Site Plan Drawing

Markup Summary

Site Plan Drawing

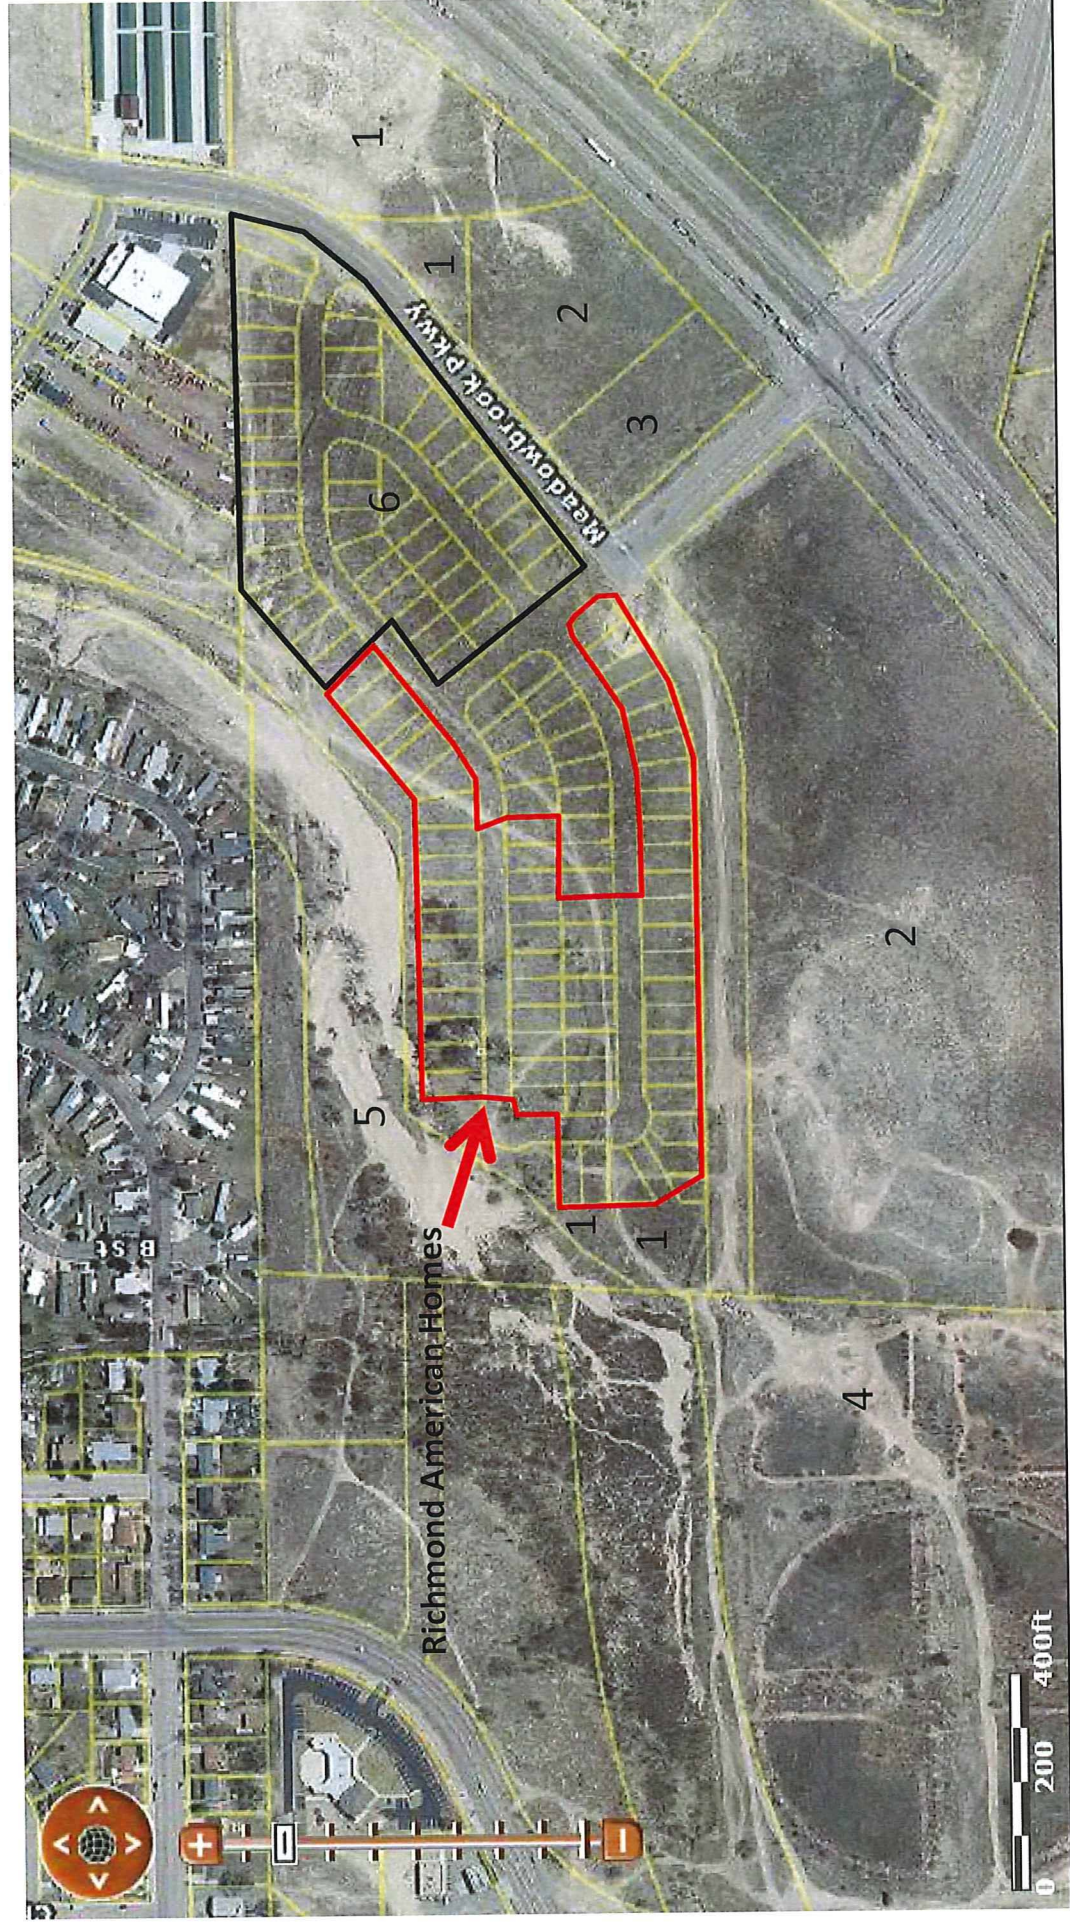
This should reflect what setbacks are being proposed on which lots, and how much lot coverage should be.
